**Re: State Significant Infrastructure (SSI-8609189) – Upper South Creek AWRC –  
Liverpool City Council Submission**

I refer to the request to provide comments on the State Significant Infrastructure - Upper South Creek Advanced Water Recycling Centre (AWRC) (SSI-8609189)

## **Attachment A - Detailed Comments/Recommendations**

Figure 9.15 Threatened species surveys and results

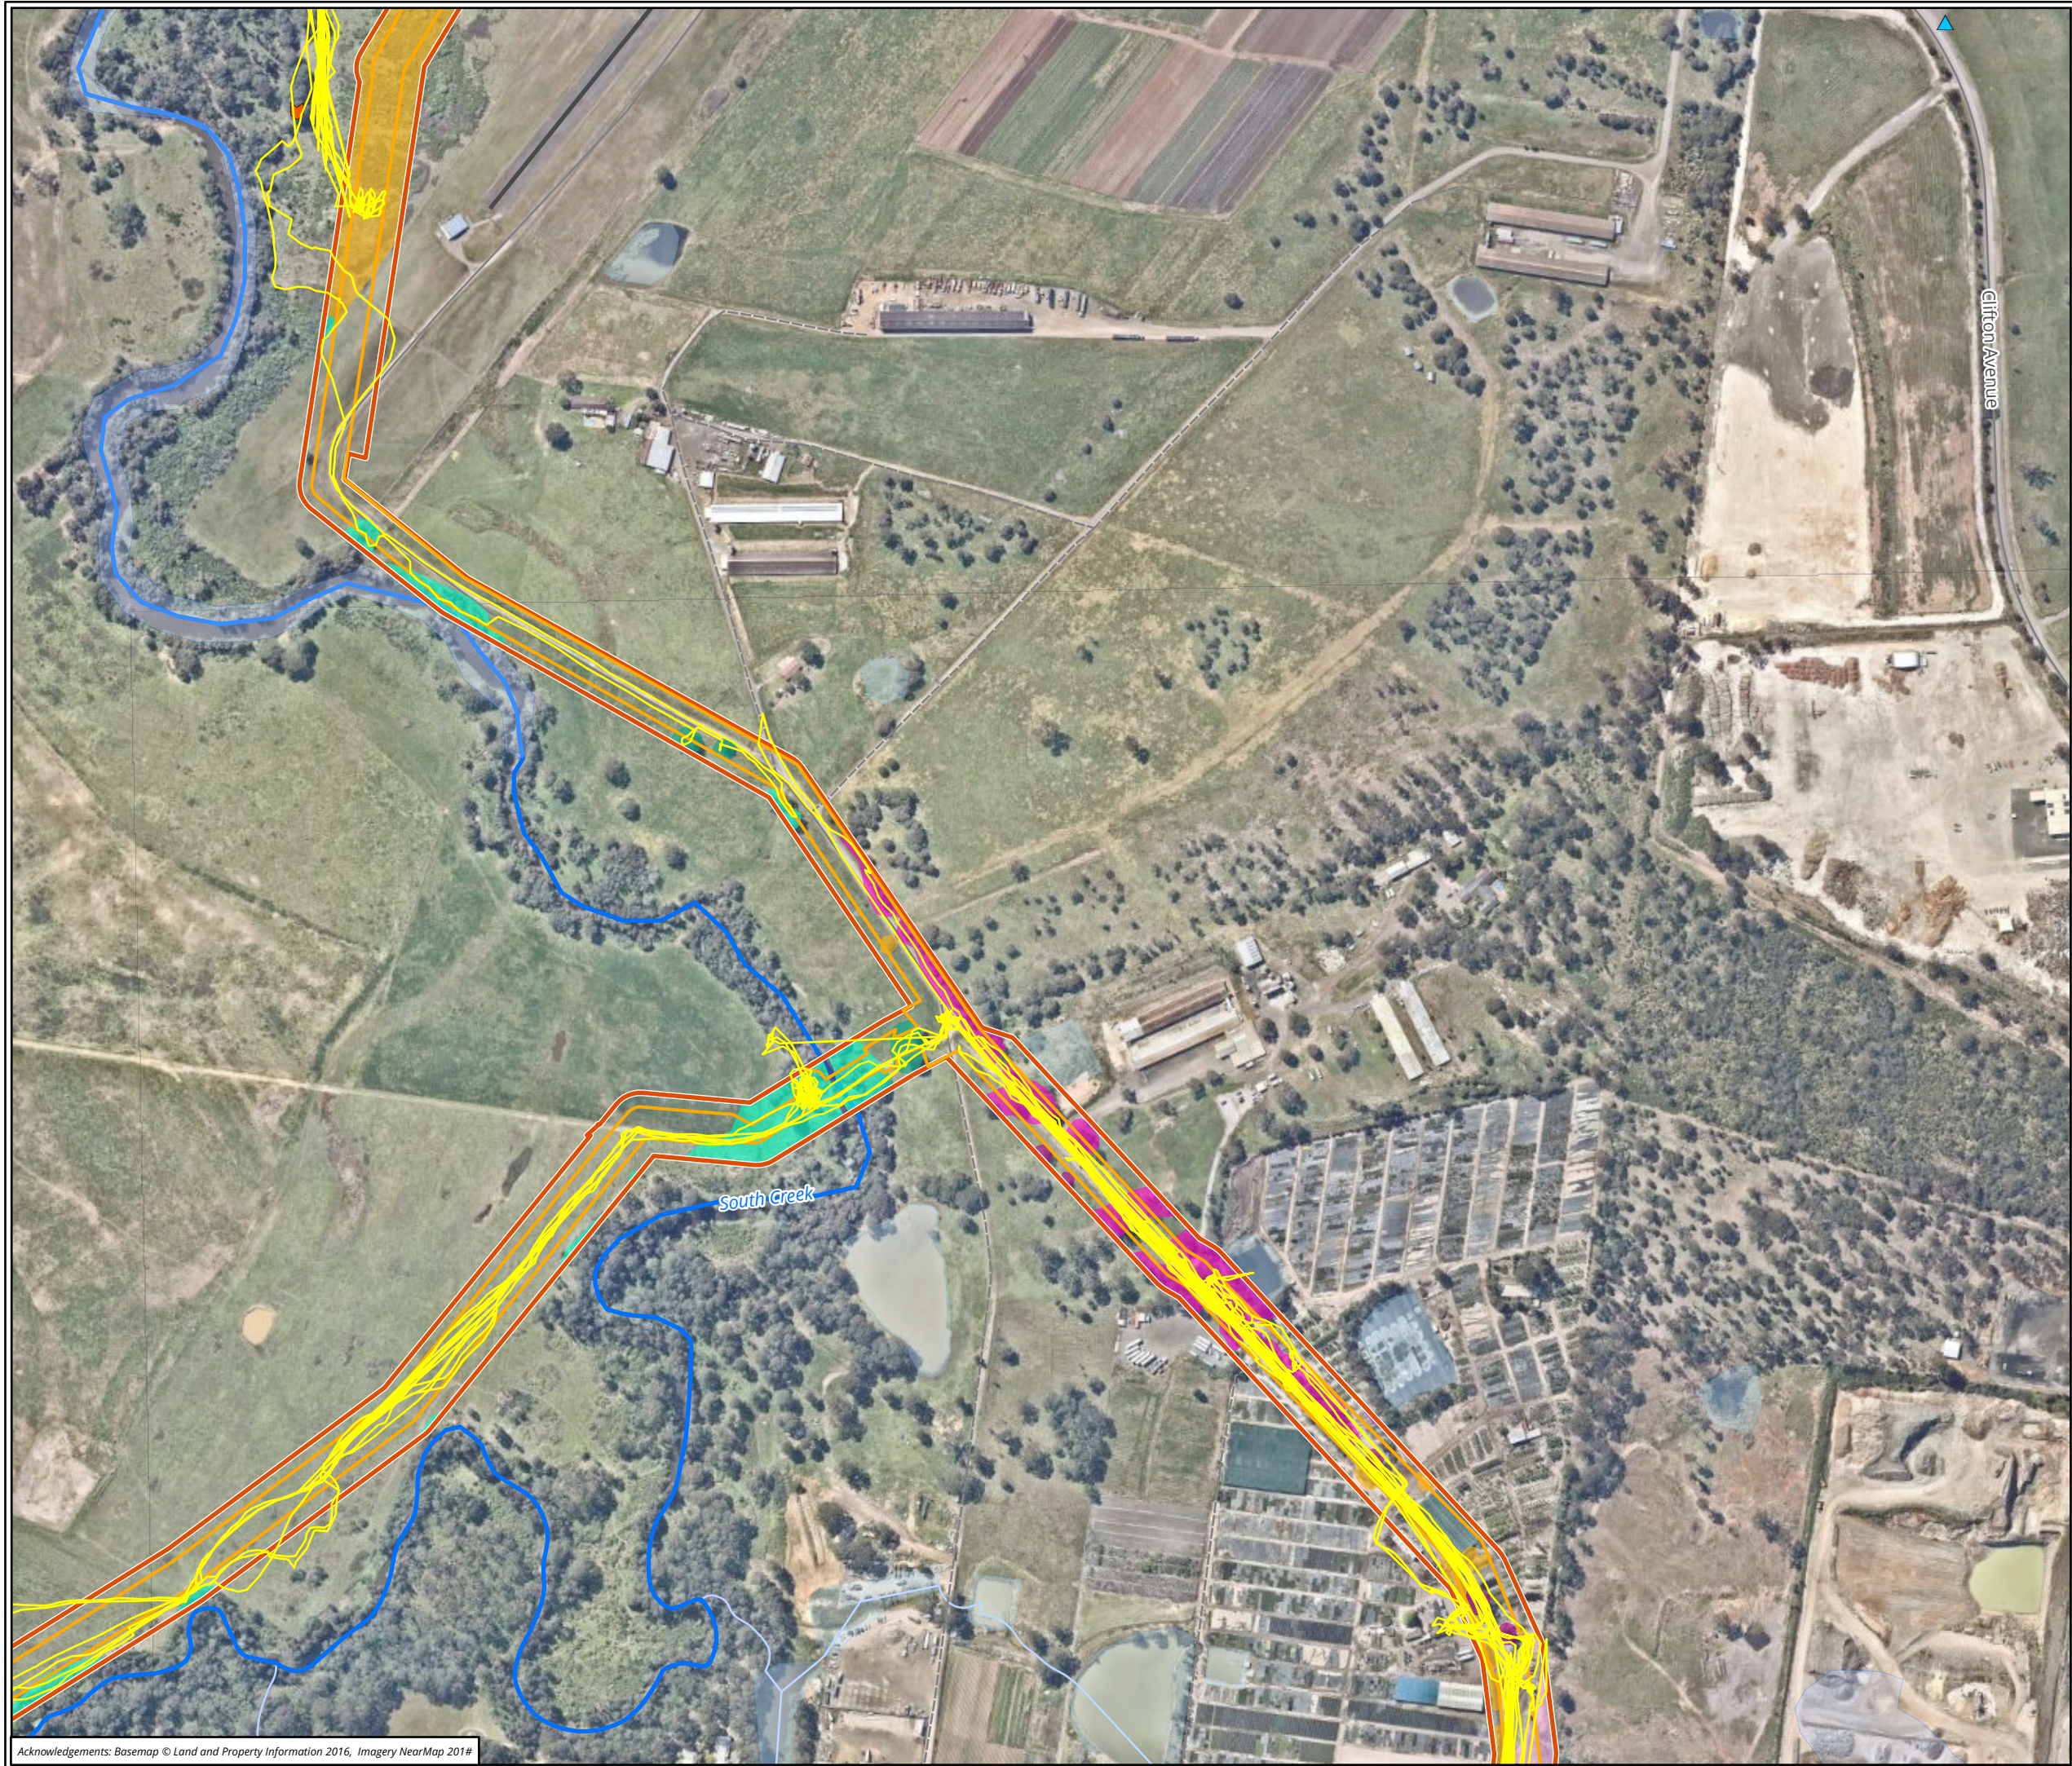
Consequently, no threatened species polygons have been identified at this locality and no direct impacts assessed. However, Figure 9.15 (Threatened species surveys and results) indicates that the impact area and many of these threatened species records are on the boundary or in very close proximity to land that is not bio-certified.

1. Caution is exercised when considering impacts on individuals within the land that is not bio-certified, given the potential for mapping errors, encroachments and impacts to the local population.
  - a. In accordance with the assumption made in the BDAR, impacts should be avoided within land not biodiversity certified. Appropriate buffers and mitigation measures should be prescribed to ensure that no adverse impacts occur.

- b. Potential impacts to these species at this location should also be specifically addressed within section 11.2 (Indirect Impacts) of the BDAR to ensure that potential impacts to their local population are appropriately considered.
